6 November 2013

Name: WILLIAM S. ARMOUR
Address: 37 CALDER ROAD
DARLINGTON NSW 2008

***Modification Request for the University of Sydney Abercrombie Precinct
Redevelopment: Application Number: MP07_0158 MOD 3***

Title
Scale
Date
Number
0 2 4
10 20m
Ground Floor Plan
MARK UP SET
1:200@A1
11.10.13
4001_DA02-D
© copyright nettleton tribe partnership pty ltd

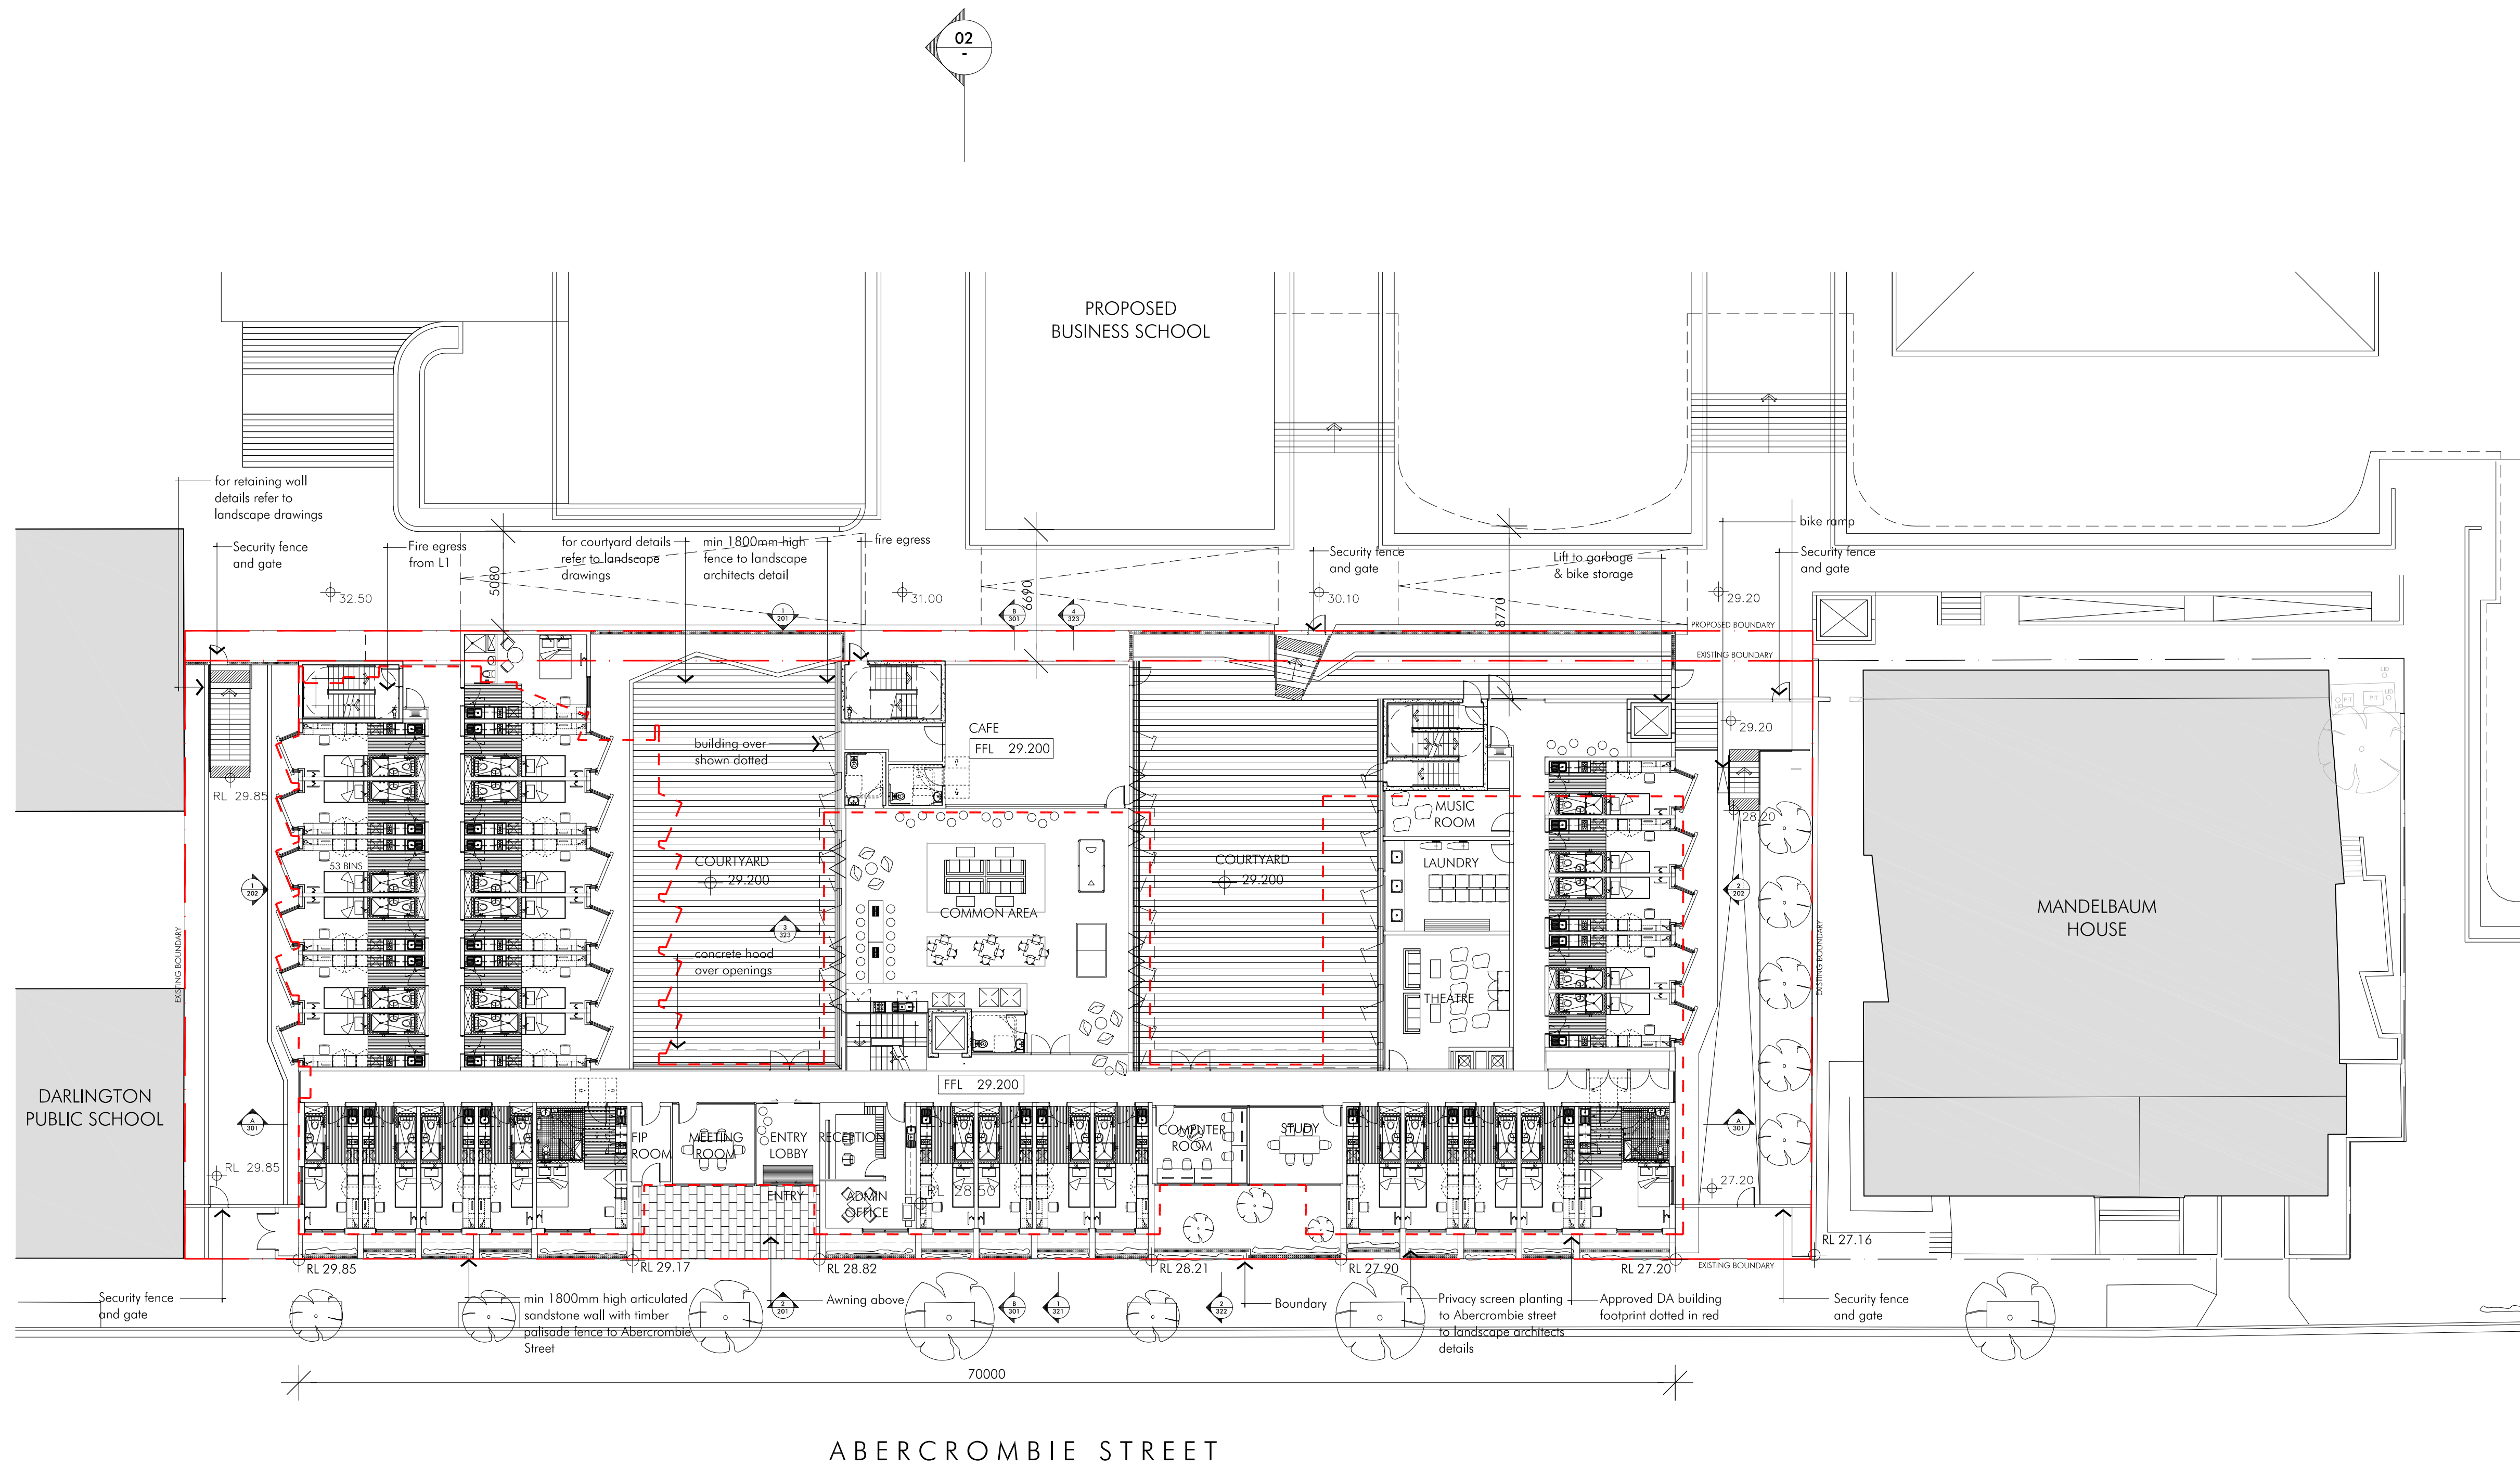
- The front of the Student Accommodation building should be built 2 metres back from the Abercrombie Street boundary. It should be set back from this boundary so that it is in line with Mandelbaum House as it was originally planned and presented to the community. The footprint of the buildings currently on the site, The Shepherd Centre and Boundary Lane Children's Centre, were built approximately 2 metres back from the Abercrombie Street boundary and align with Mandelbaum house. Therefore, the front footprint of the proposed Student Accommodation building should be the same as those buildings occupying the site at present and not be built up to the Abercrombie street boundary.

- The facade of the proposed Student Accommodation building does not reflect the heritage appearance of the Victorian terraces on Abercrombie Street as Mandelbaum House does. Therefore, it should be set back to allow for extensive vegetation and trees to be planted in front of the building on Abercrombie Street to help preserve the heritage streetscape and improve both the aesthetics and the environment of the street.
